Our Ref: BE/128/14/A

**Town & Country Planning (Control of Advertisement) (England) Regulations 2007 (as amended)
Application for Consent to Display an Advertisement(s)**

Development 3 No. internally illuminated fascia signs, 1 No. internally illuminated moulded totem sign & 3 No. non illuminated wall mounted signs.

Location Kwik Fit Unit 7 Southern Cross Trading Estate Oldlands Way, Bersted Bognor Regis

Site Plan

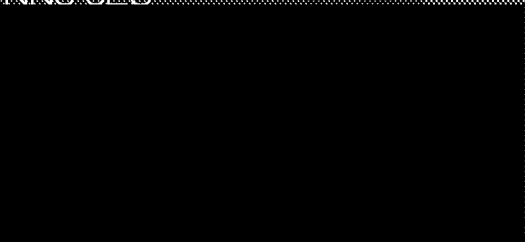
The site plan provided only indicate 6 signs, please indicate all proposed signage.
